6 April 2022

Art Gallery of NSW Expansion Project – Sydney Modern (SSD 6471-MOD 8) for Minor External and Landscape Design changes

The following documents relating to the modified proposal have been reviewed:

Sheet No.
LD_DA_00-02

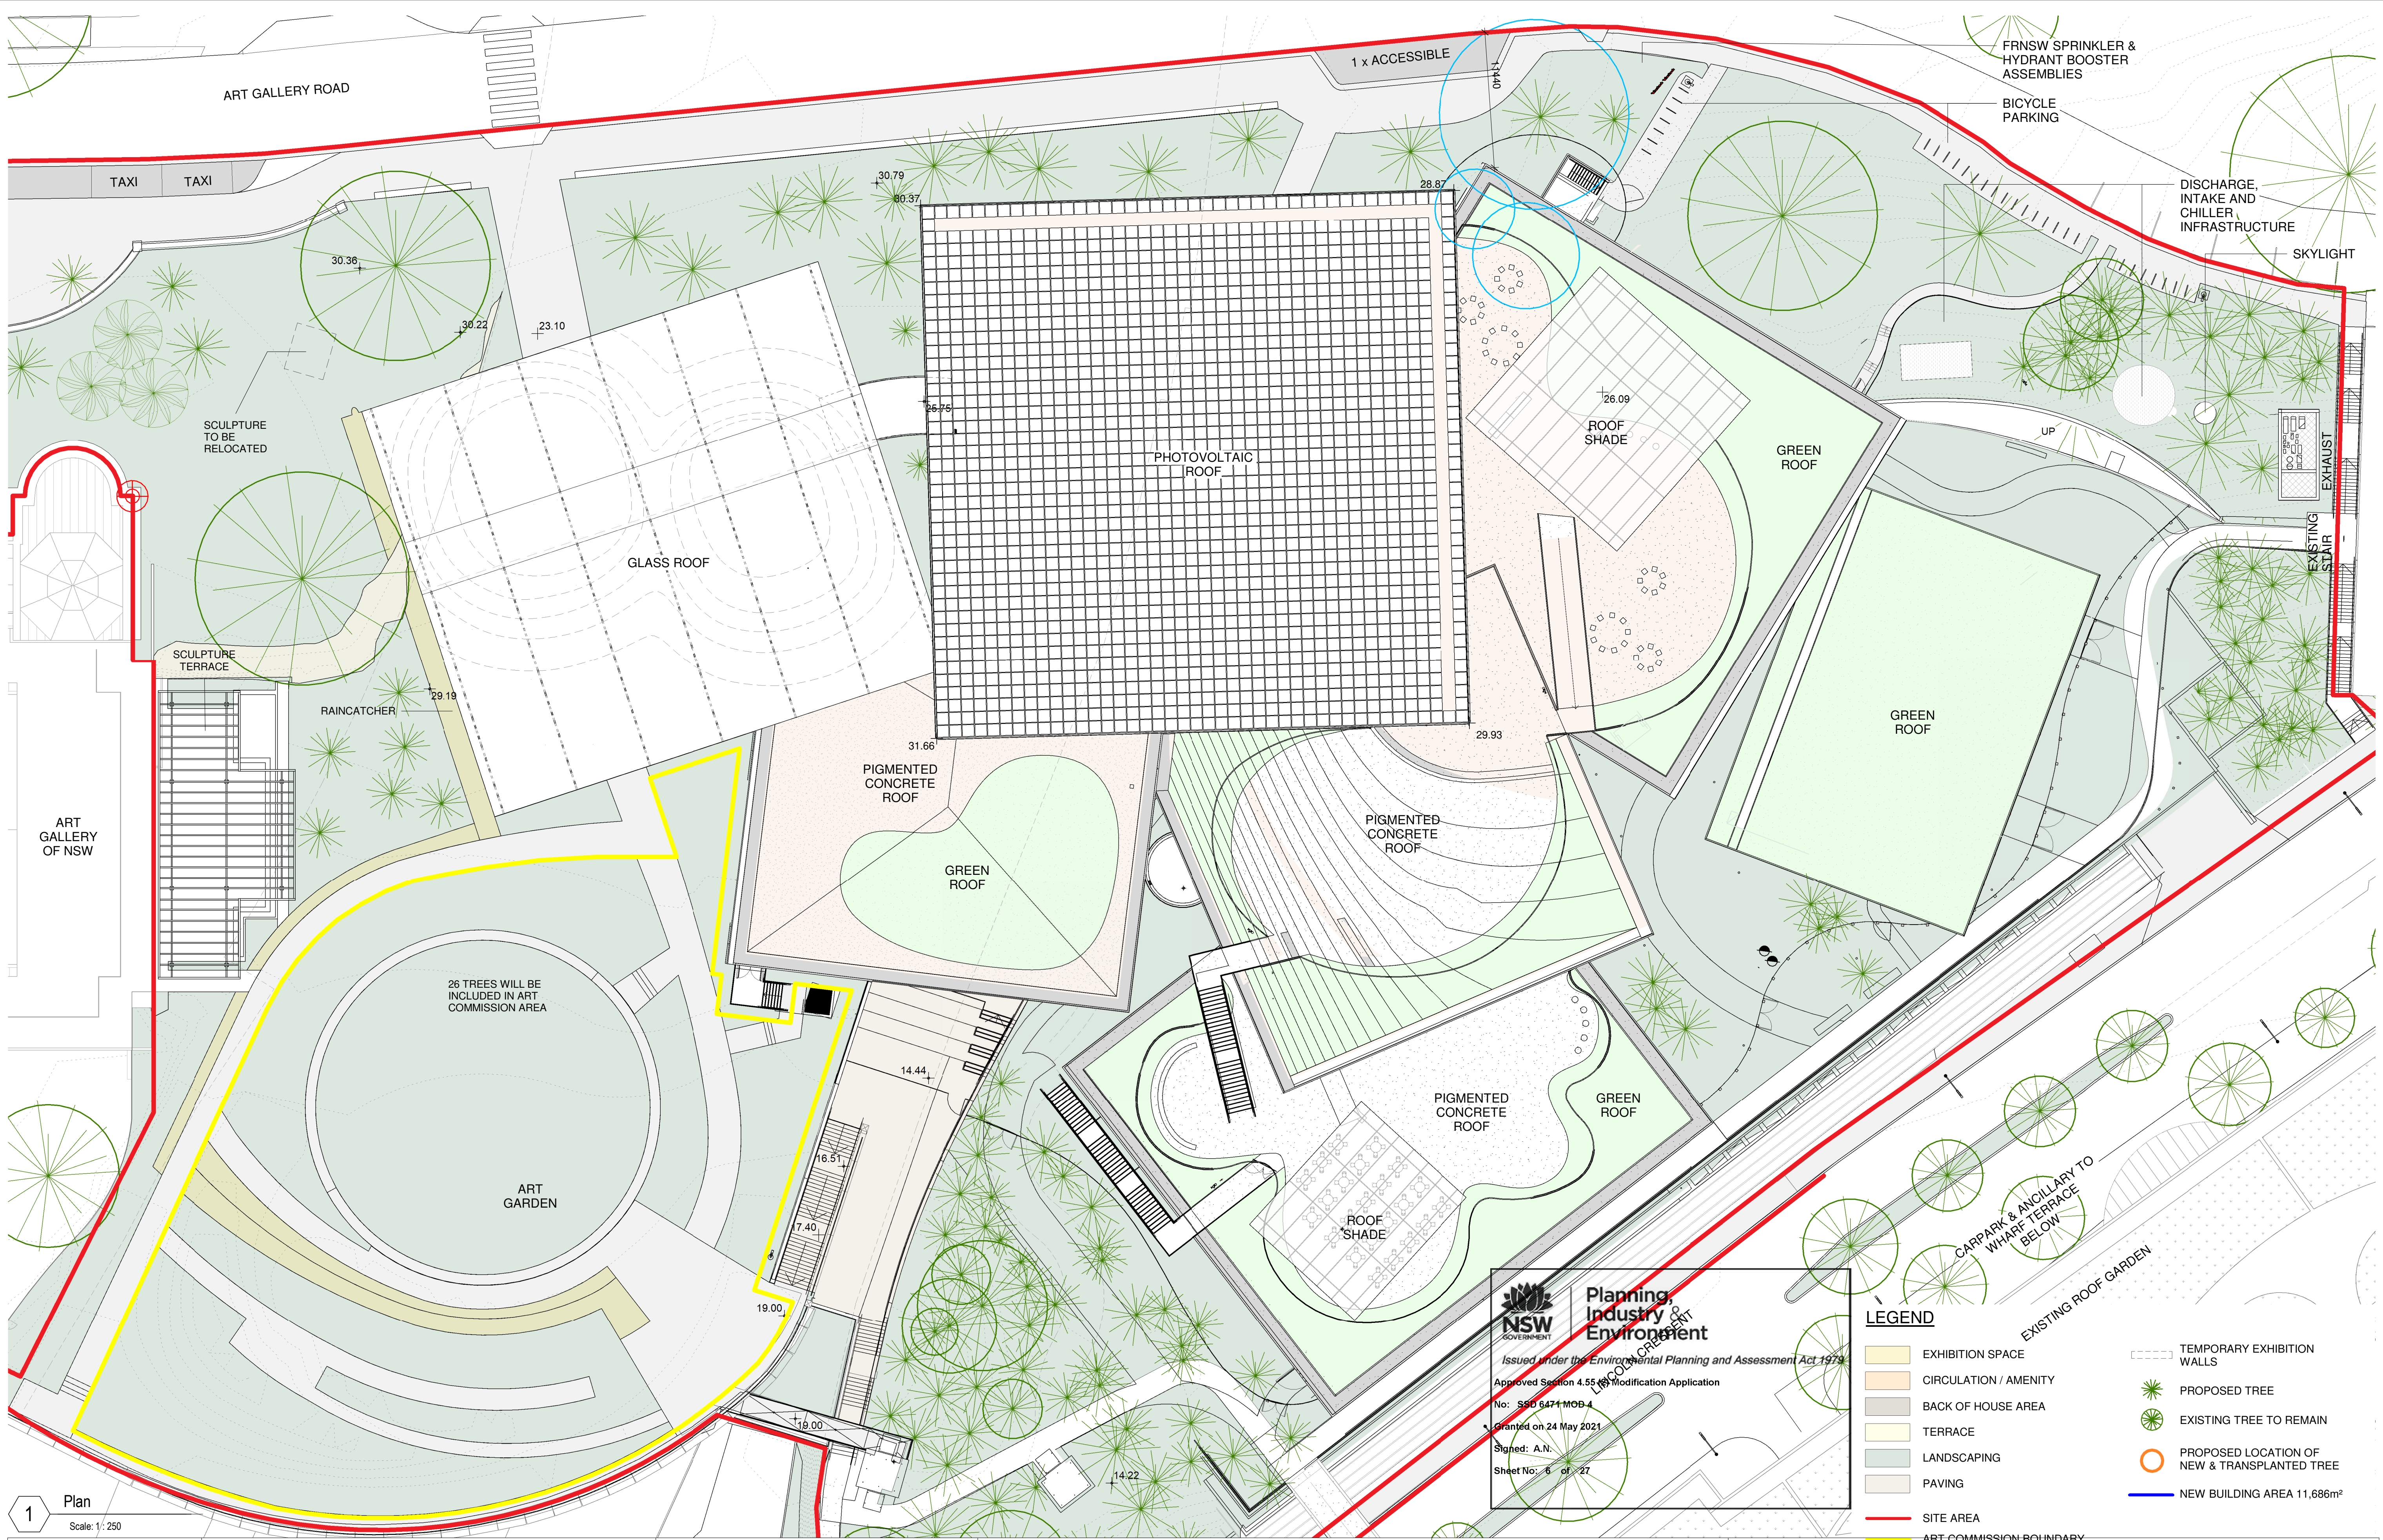
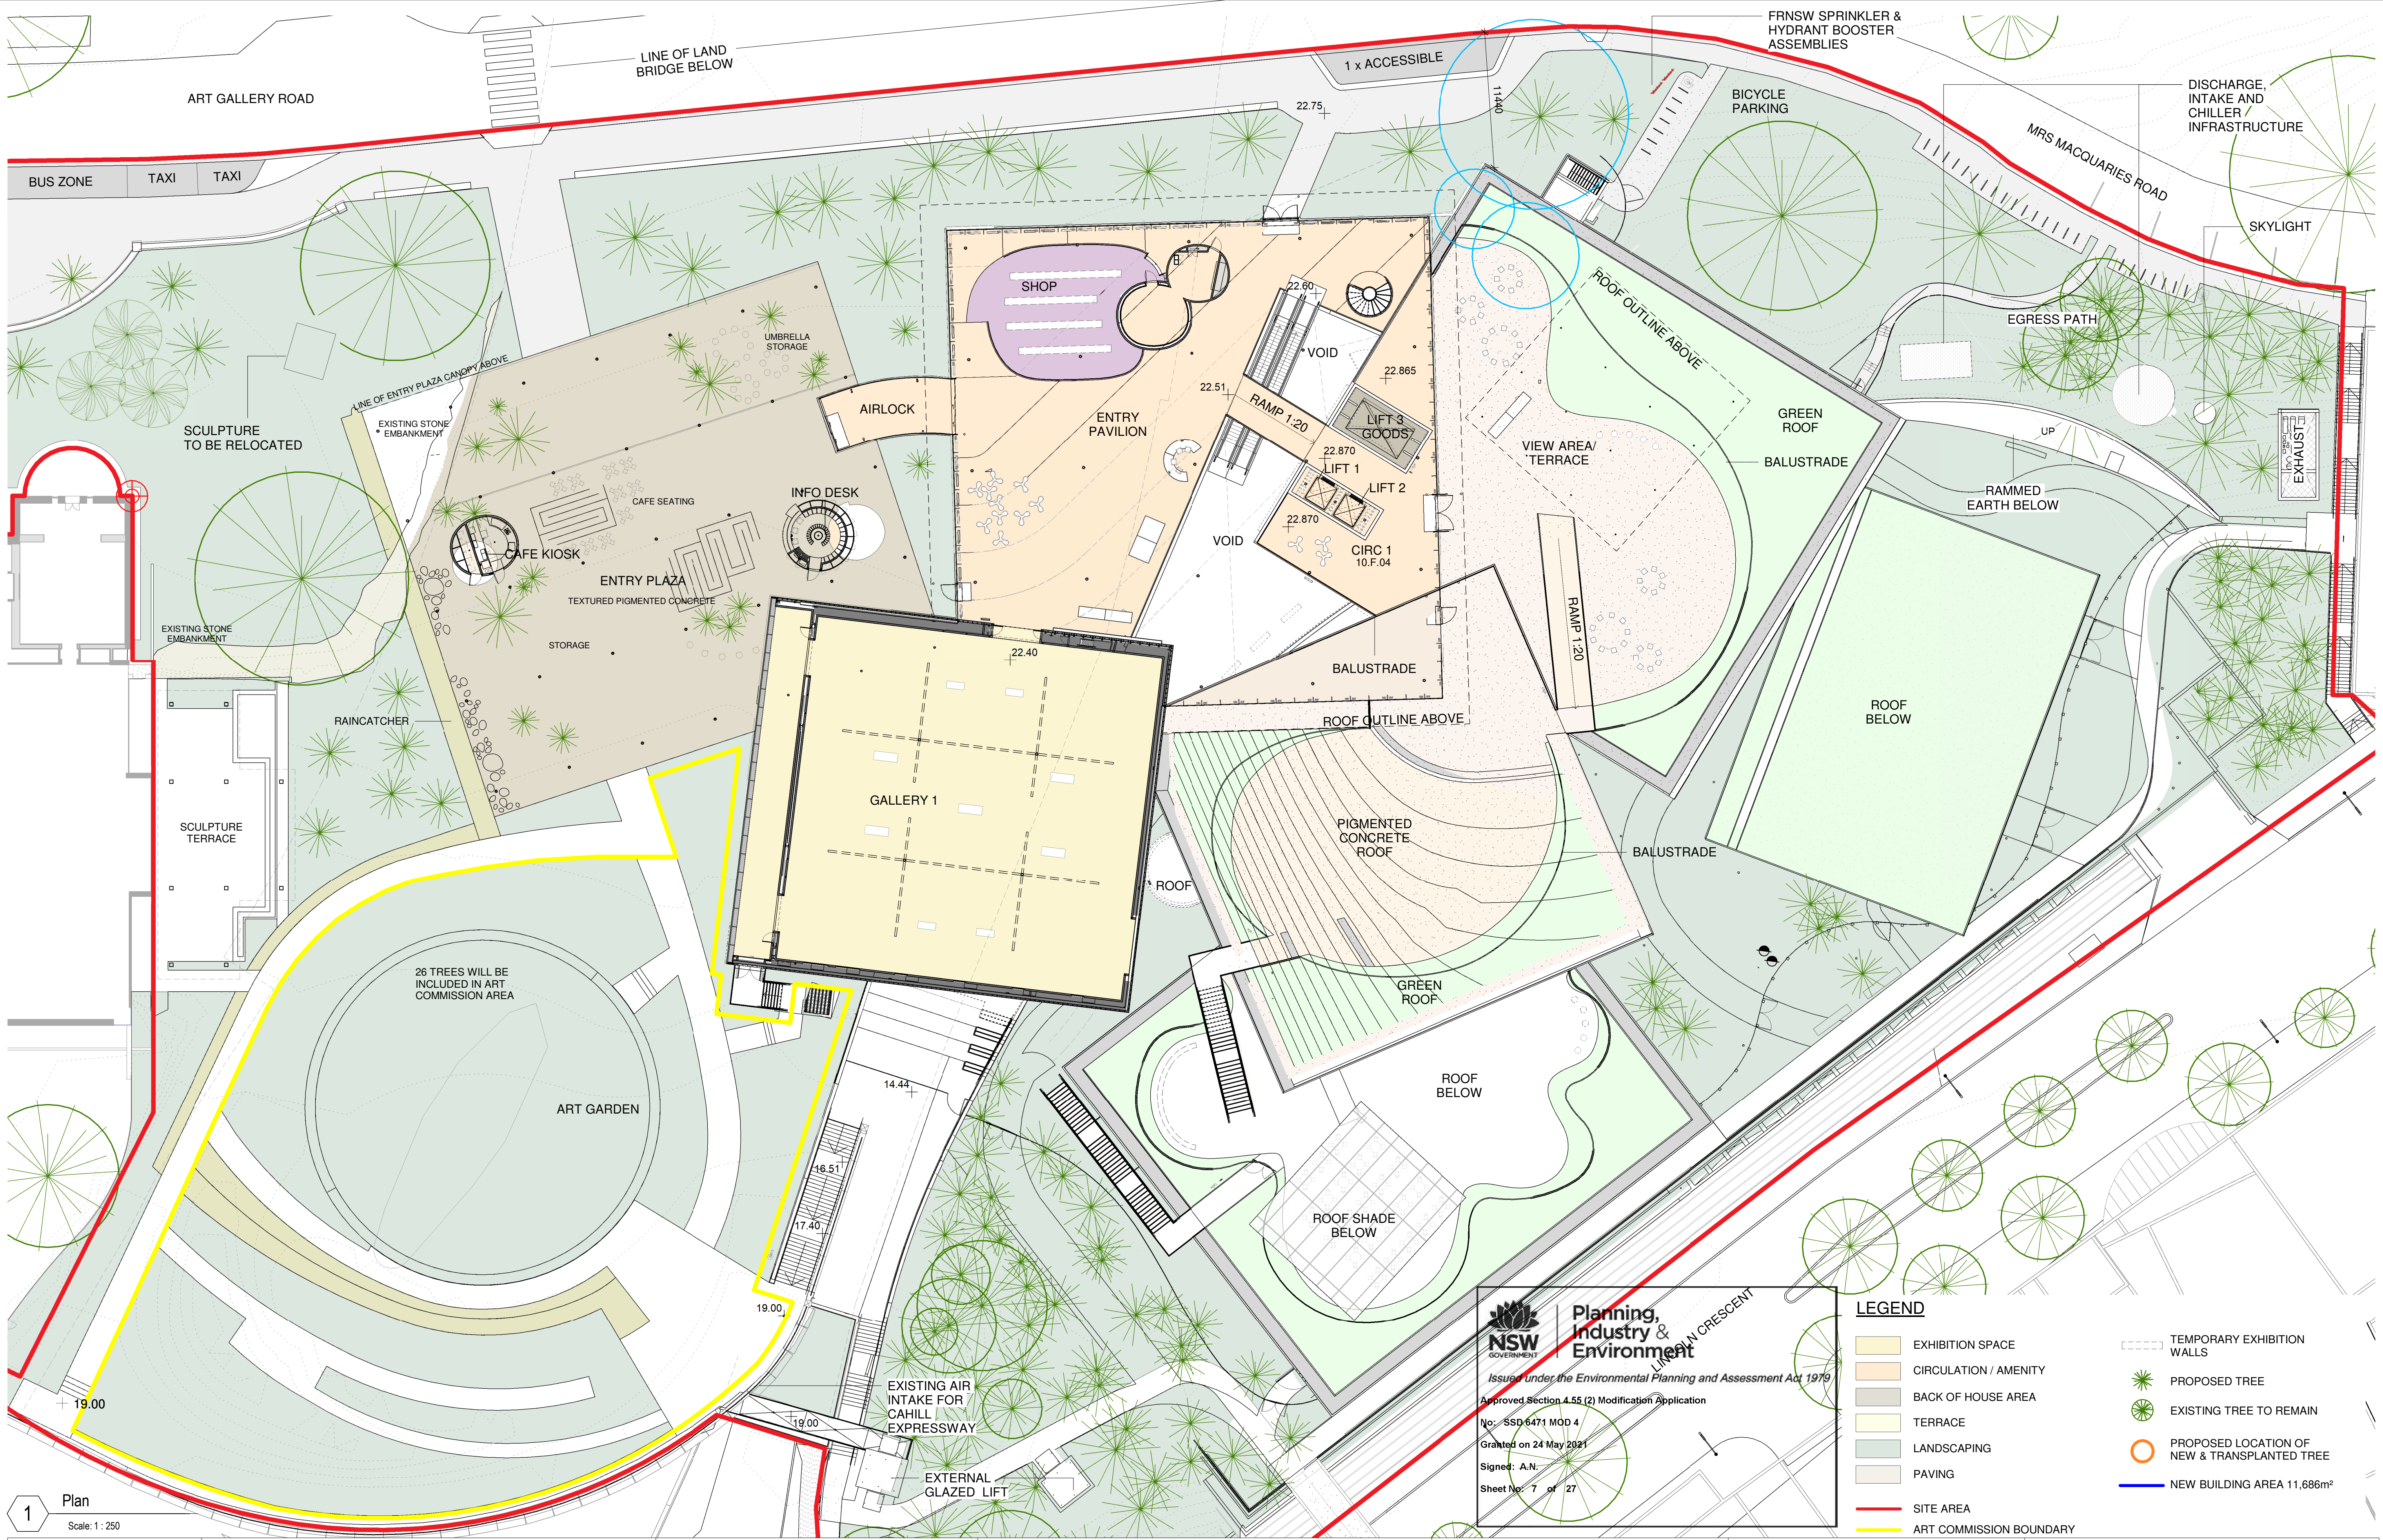
The area from the eastern kerb line of Art Gallery Road and to the West do not form part of the Sydney Modern licence area but for the purposes of enhancing the transition between the Domain and the Art Gallery the Trust has worked with the Gallery to redesign the “hammerhead” area shown on the Amended Architectural Plans.

The Trust does not support the treatments and finishes as proposed for this area as these are at odds with the broader Domain. In addition, the Trust will be the asset owner of the works in this area and will assume the lifecycle liabilities that will arise. Specific points of note are as follows:

- **Granite steps** - Granite steps are not used throughout the Domain – the dominant material is sandstone, and the works will result in the removal of existing sandstone steps. The Trust requires that sandstone steps are used in the area defined above

- **Concrete paving and flagging** - Concrete and other flagging materials are not used in the Domain for paths or pedestrian access areas. This is due to the large numbers of figs in the space with an extensive and water seeking root system. This results in repeated lifting of slabs and materials creating trip hazards which then give rise to a public liability risk to the RBGDT. The standard material throughout the Domain is asphalt. The Trust requires that this material to the Trust's specification be installed in the affected "hammerhead" area.

- **Wombat crossing** - While the Trust agrees and supports the installation of the wombat crossing the design and profile of the crossing must be such that facilitates and minimally disrupts the movement of cyclists. The Domain has been used for significant cycling events which support the revenue and operations of the Trust and any crossing profile that ignores the need of cyclist places unnecessary pressure on Trust activities through loss of revenue.

- **Other matters** - There is insufficient detail provided to allow for a considered final approval on the affected area of the design and the Trust must (as the owner of the asset at the end of the construction work) sign off on the elements and materials proposed to be installed including but not limited to
